From: Kingston Parish Council 
Sent: 20 August 2015 11:50
To: Ross Leal
Cc: Geoff Palmer
Subject: Fwd: Fwd: Planning Application K/22/15/CLP (Broadbeach, 39 Coastal Road)

From: Sue Bowley
On Behalf Of Planning
Sent: 14 August 2015 11:17
To: Ross Leal
Subject: FW: Planning Application K/22/15/CLP (Broadbeach, 39 Coastal Road)

Subject: Fwd: Planning Application K/22/15/CLP (Broadbeach, 39 Coastal Road)

Proposed West & East Elevations  
(alterations and extensions)

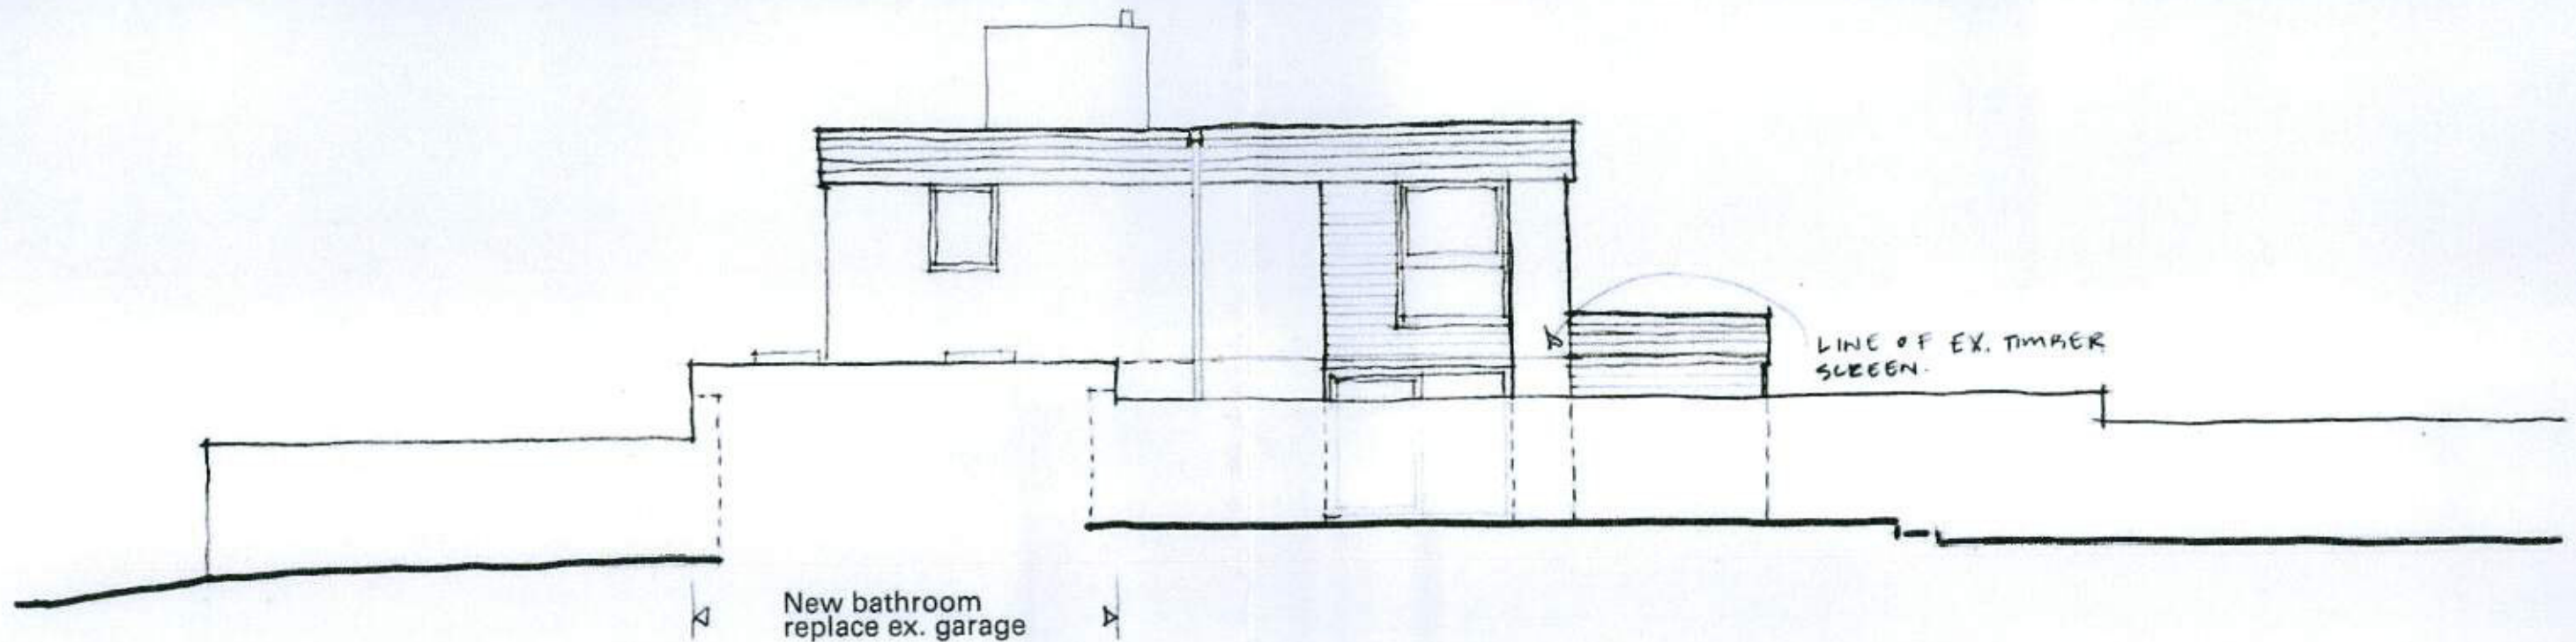
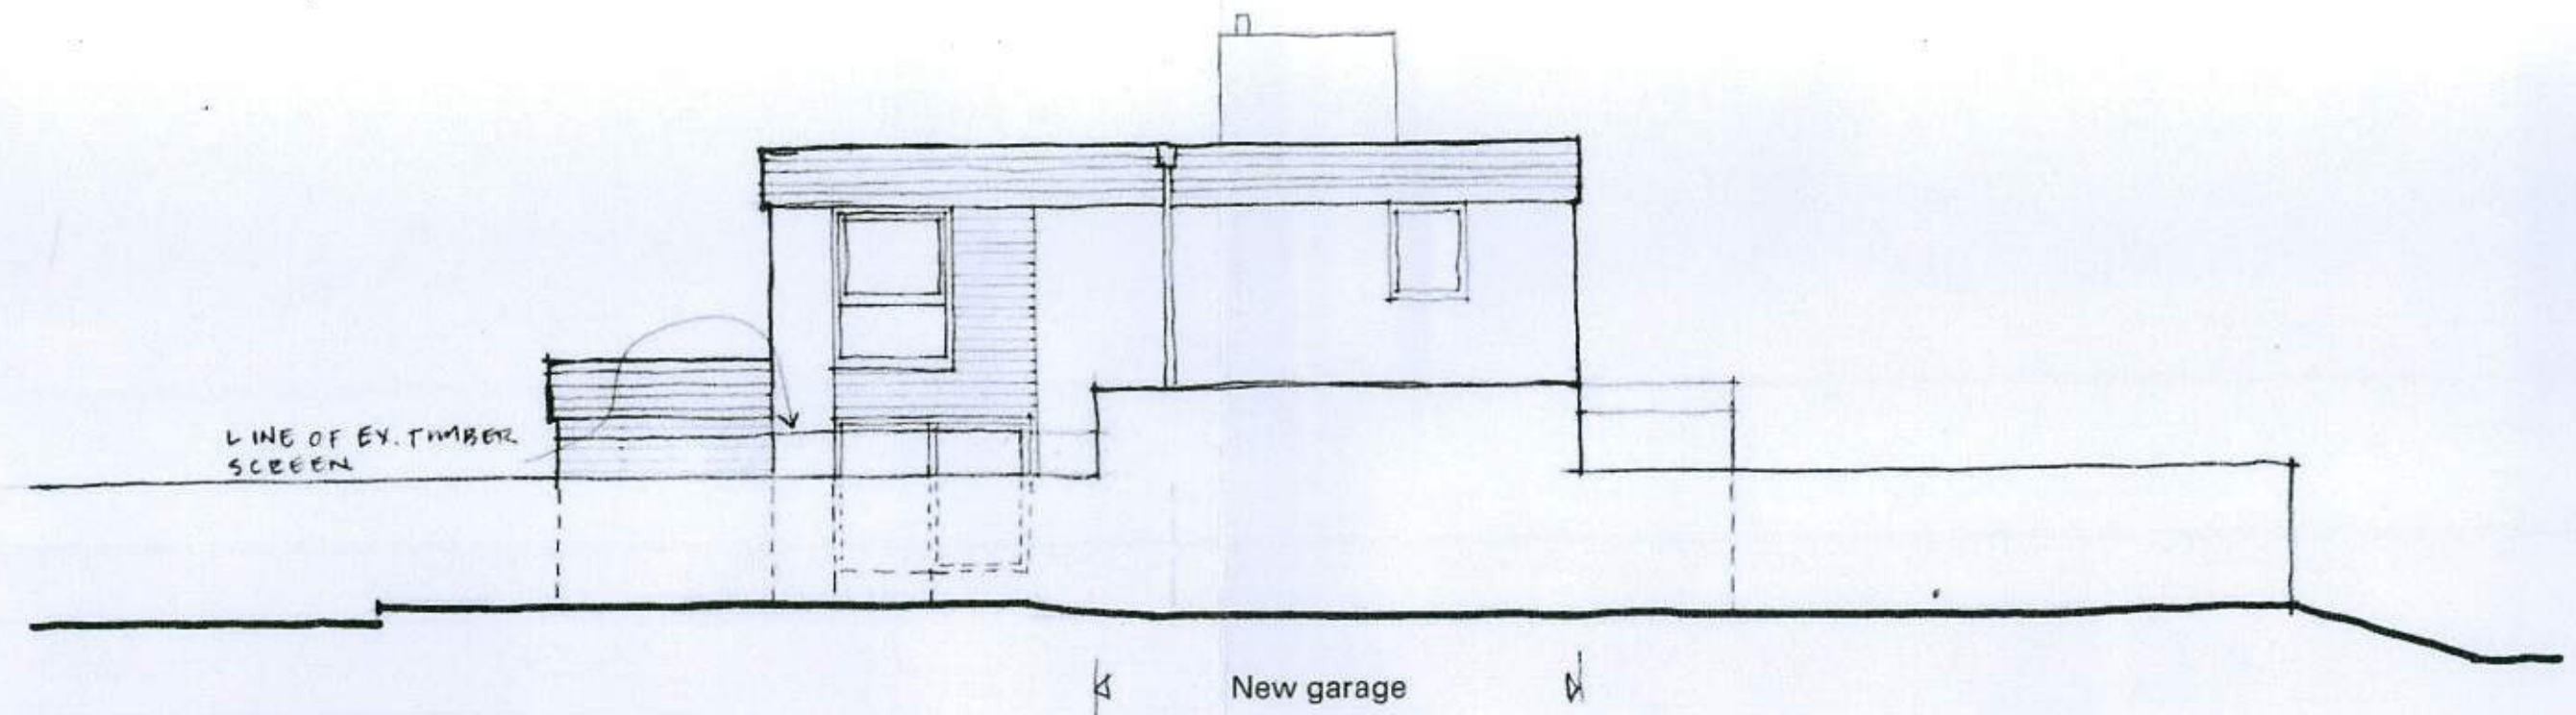
The existing flat roof above the porch, entrance hall and integral garage is part of the original property as constructed in the late 1960s. The applicants are proposing to replace part of this roof with a higher roof which extends to the side of the property as indicated.

Proposed North & South Elevation
 (alterations and extensions)

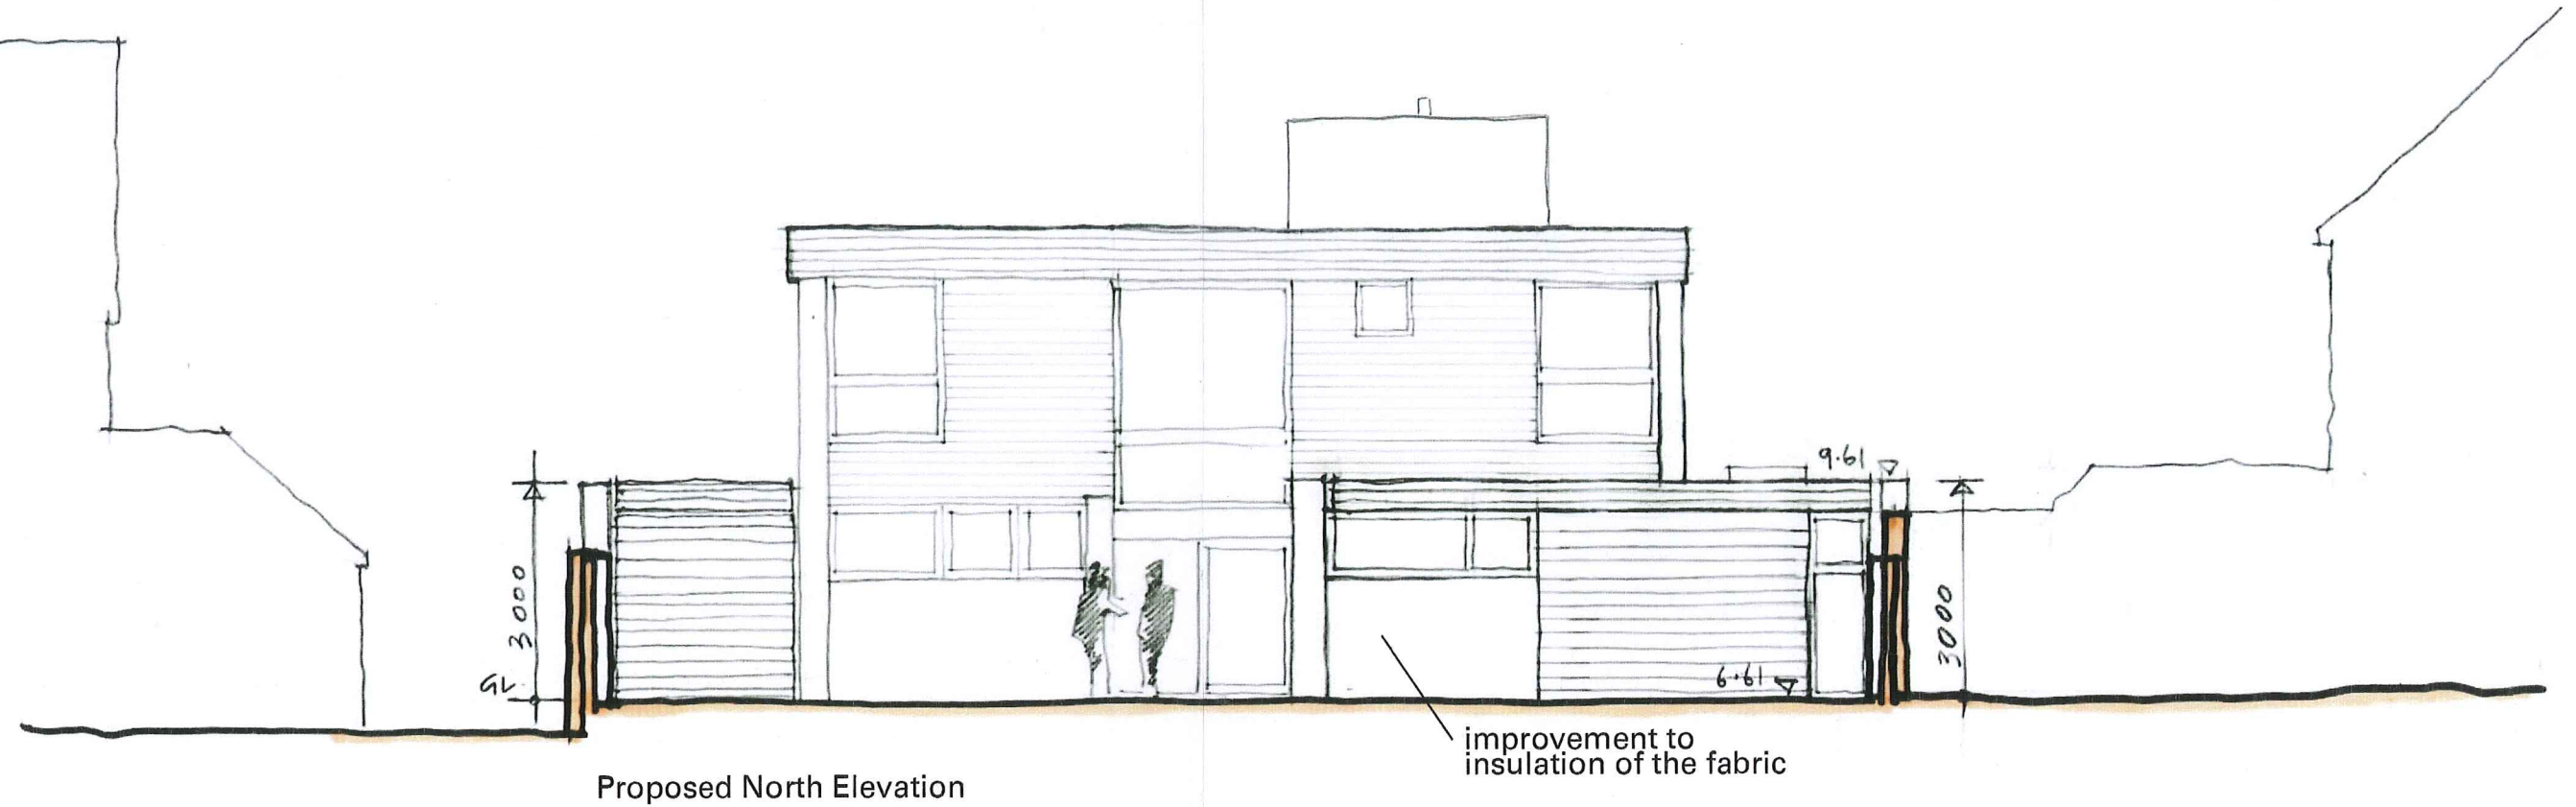
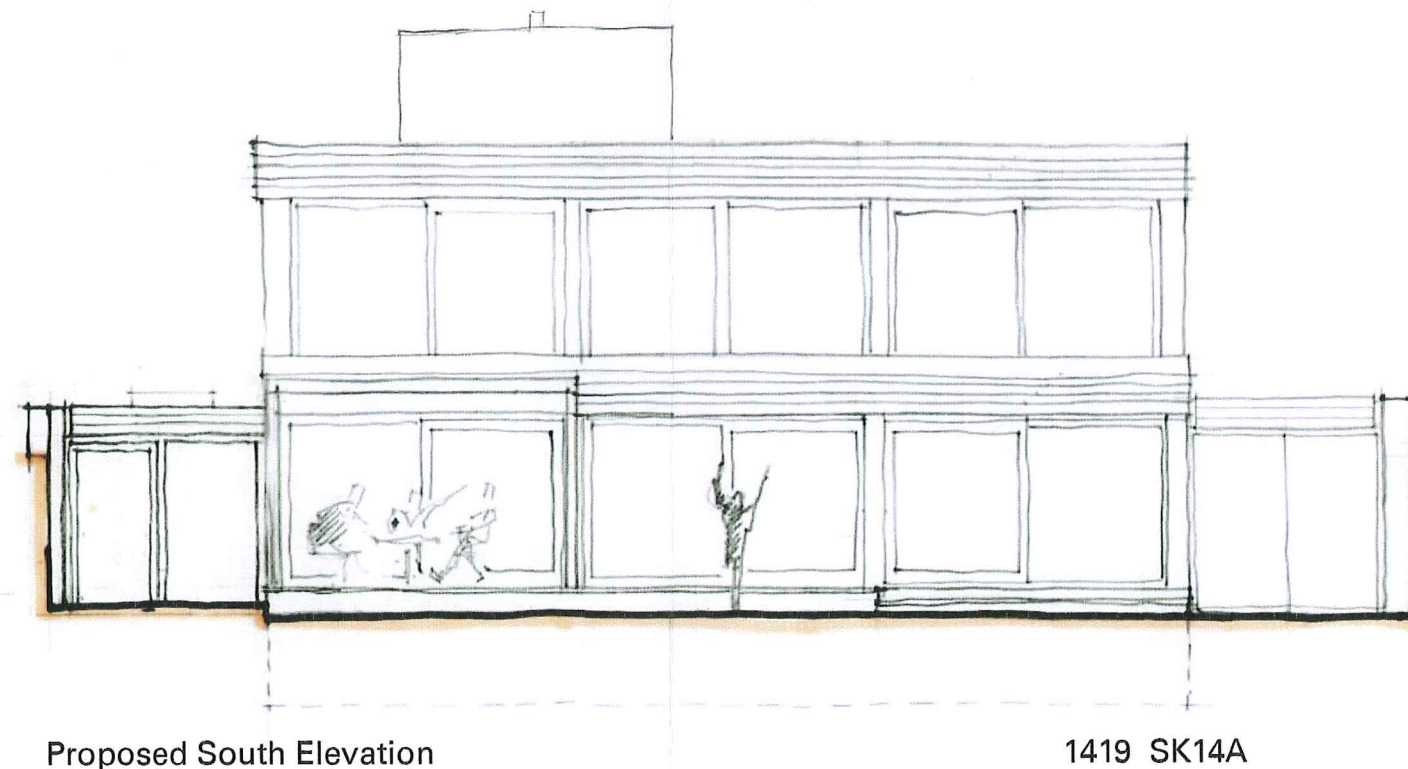
The Planning Order 2015 relating to Permitted Development states that "Development is not permitted by Class A *if it would consist of or include an alteration to any part of the roof of the dwellinghouse*" (Class A.1.(k)(iv)). Part of this roof is being raised in order to convert the integral garage into a bedroom which falls into the scope of Class A (the *"enlargement, improvement or other alteration of a dwelling house"*). It is therefore not Permitted Development.

We understand that alterations to the roof are permitted under Class B of the Planning Order providing that *"other than the case of an enlargement which joins the original roof to the roof of a rear or side extension, no part of the enlargement extends beyond the outside face of any external wall of the original part of dwellinghouse"* (Class B.2. (b)(ii)). However, this does not apply in this case as it is a new roof (not the original roof) which would be joined to the new side extension.

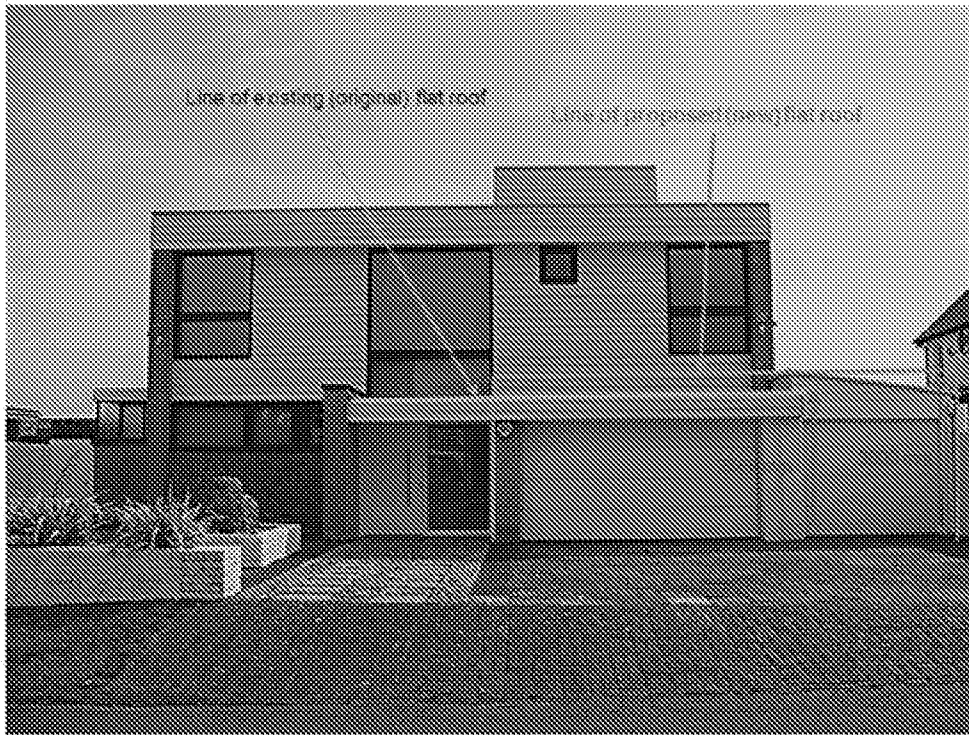
Further to the representation on the above planning application which we made via the website yesterday, we have attached a photograph to illustrate why we consider the proposals in the above planning application fall outside the scope of Permitted Development.
